**Application by:- Norfolk Vanguard Limited for an Order Granting Development Consent for the Norfolk Vanguard Offshore Wind Farm Project**

Your Ref: EN010079  
Date: 12 February 2019

Please find below the Local Highway Authority (LHA) post hearing submissions arising from Issue Specific Hearings (ISH) 1 & 3.

Title:
ExA; ISH; 10.D3.1A
Location of Hornsea Project Three main compound

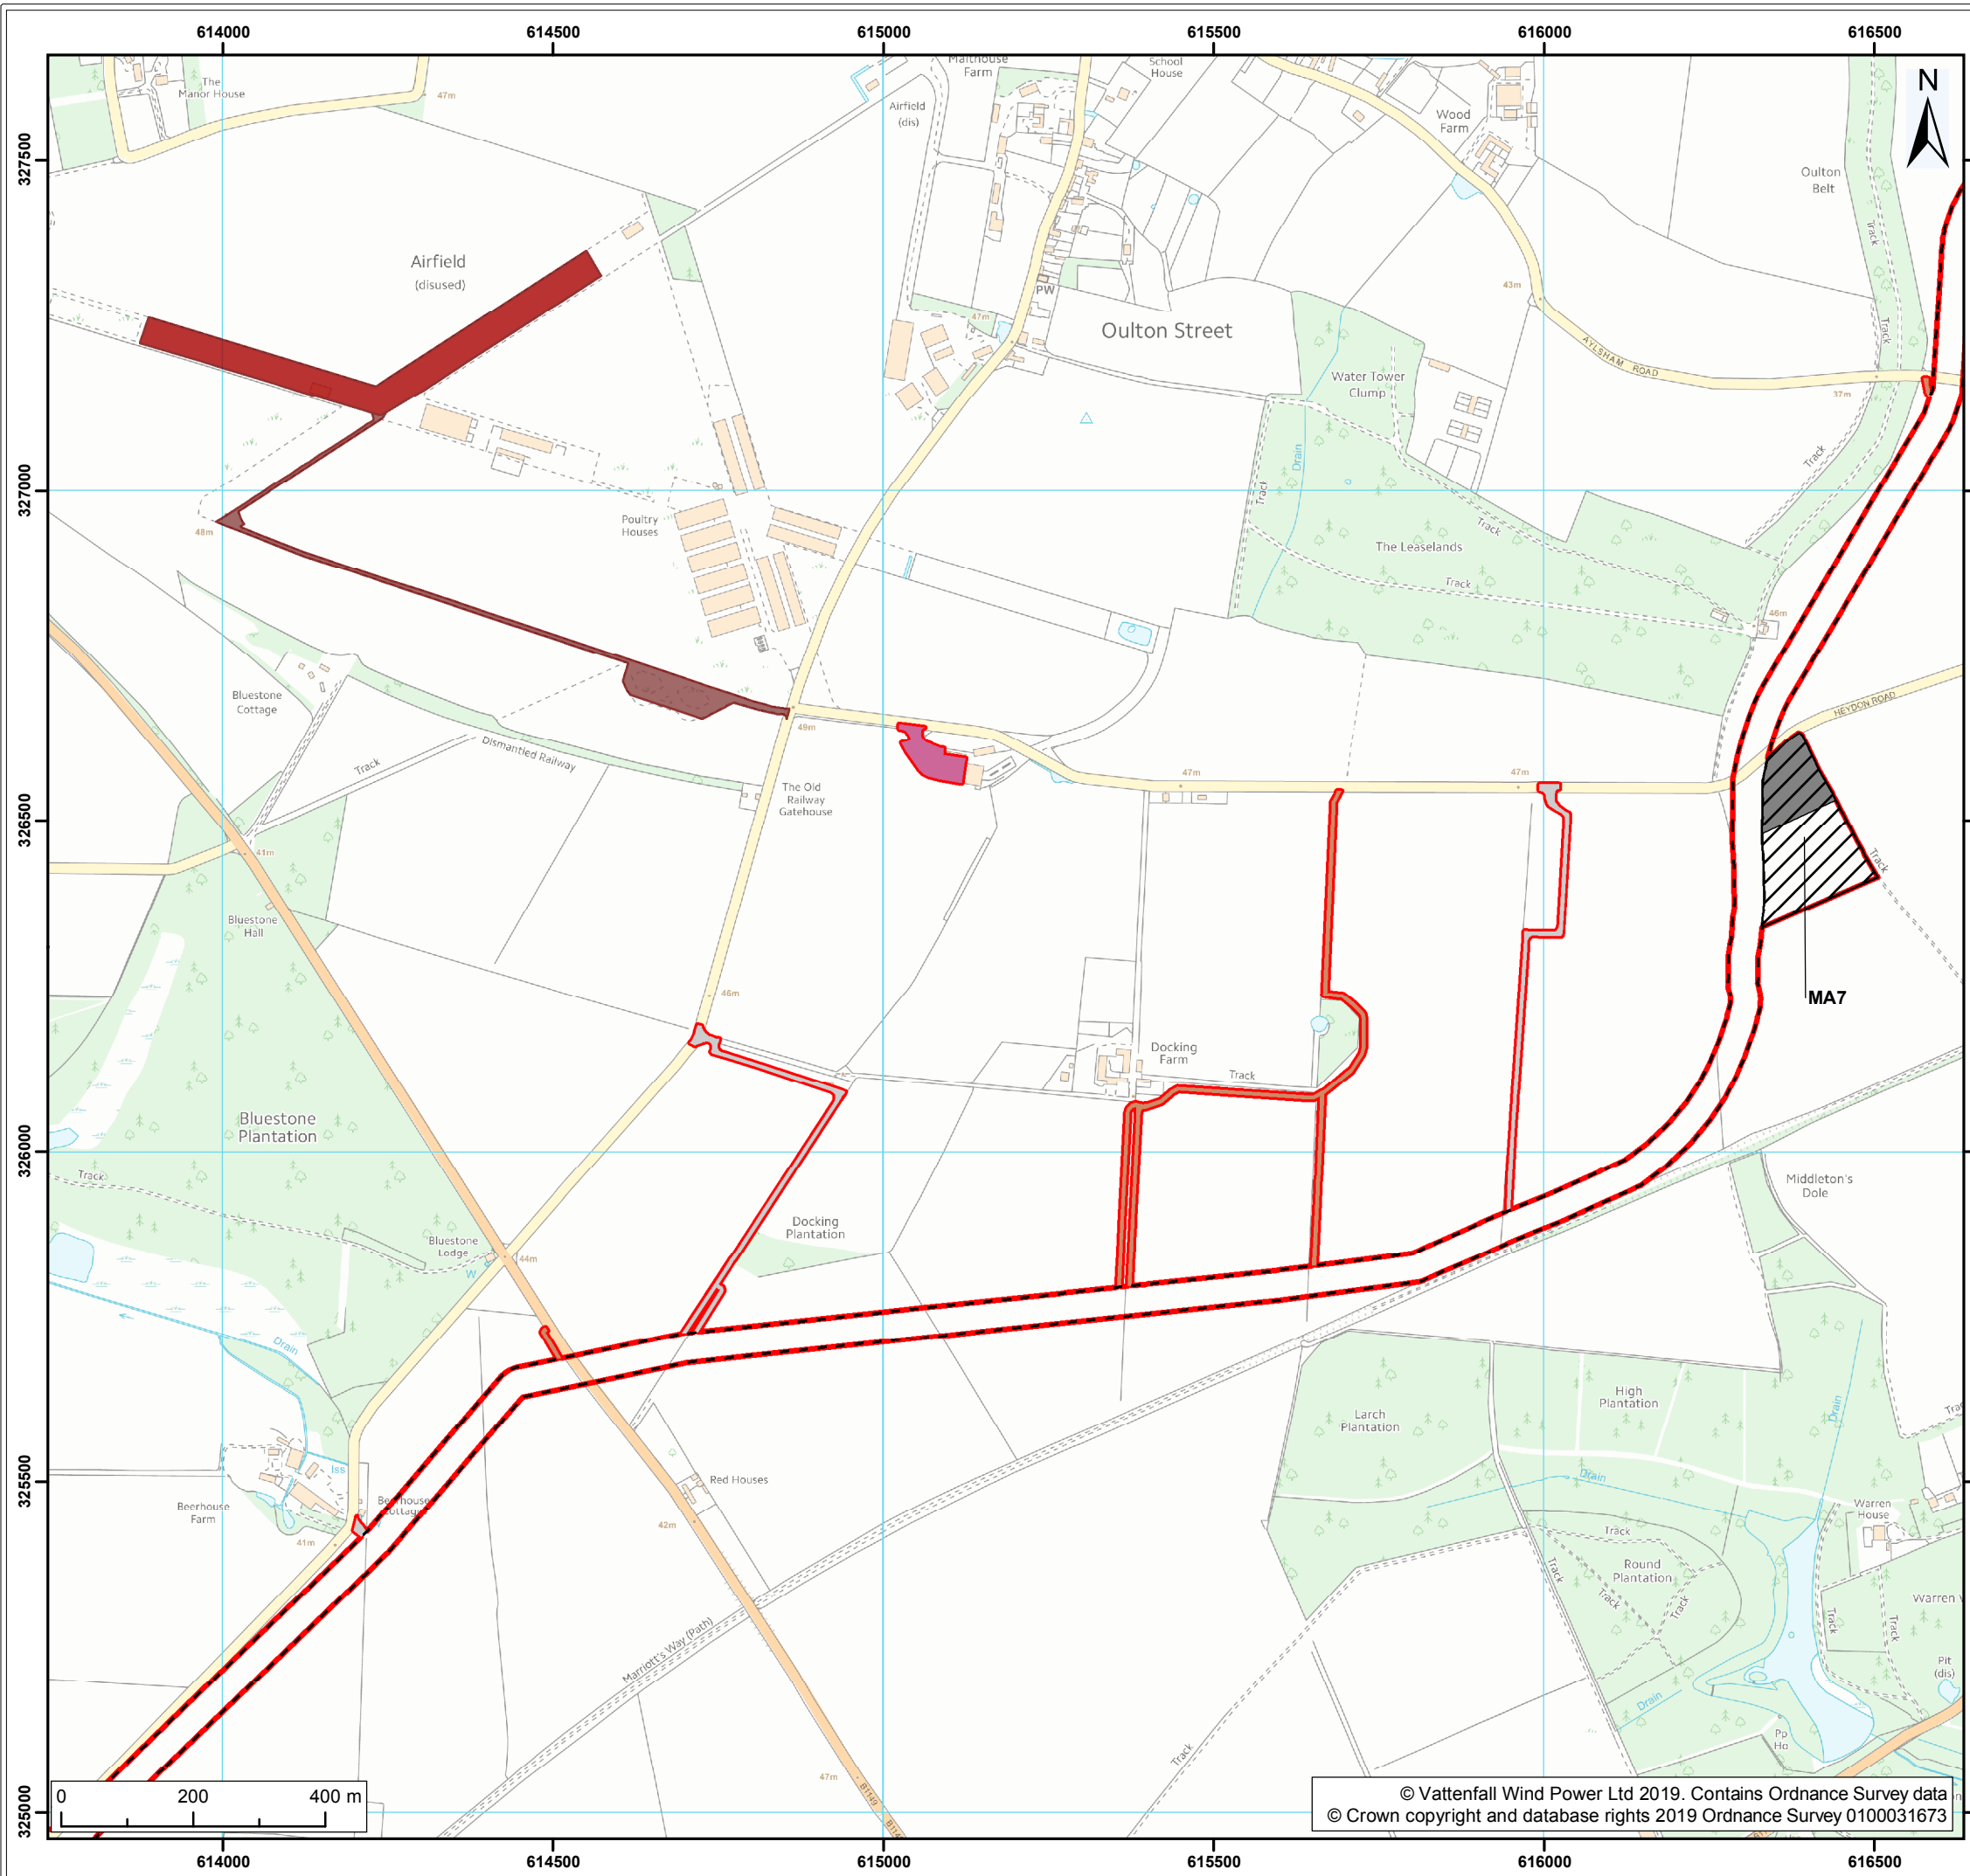
**The Street at Oulton**

This link serves mobilisation area MA7 and is identified as requiring traffic management measures. The LHA remains adamant the applicants need to mitigate against their impact.

As indicated within our letter to the ExA dated 15 January, the LHA supports a mitigation scheme proposed by Ørsted (the Applicants for Hornsea 3) which we believe overcomes the issue of either Vanguard or Ørsted using link 68 independently of each other.

As the programme currently stands, Ørsted will come along first, provide the mitigation measures and will be last to leave the site. Accordingly, Ørsted are committed to providing the mitigation works and subsequently removing them with Vanguard coming along somewhere in between.

However, the concerns raised by the LHA are (i) Hornsea 3 may be delayed, such that the mitigation works will not be in place prior to Vanguard utilising this link or (ii) Vanguard may be delayed such that the mitigation works will be provided and subsequently removed prior to Vanguard utilising this link.

At ISH1, the applicants offered to meet the LHA to try and find a solution, however, they also stated their position will be on the basis they only need to deliver only **part** of the overall mitigation scheme.

The LHA wish to make it very clear the above is unlikely to be acceptable. Our concern is Hornsea 3 may be delayed, Vanguard would then deliver part of the off-site improvement scheme and then start to use link 68. If Hornsea 3 then come on stream before Vanguard ceases to use the link, Hornsea would have to dig up link 68 whilst Vanguard are in the process of using it. Clearly, such a prospect does not work and there needs to be a more co-ordinated approach.
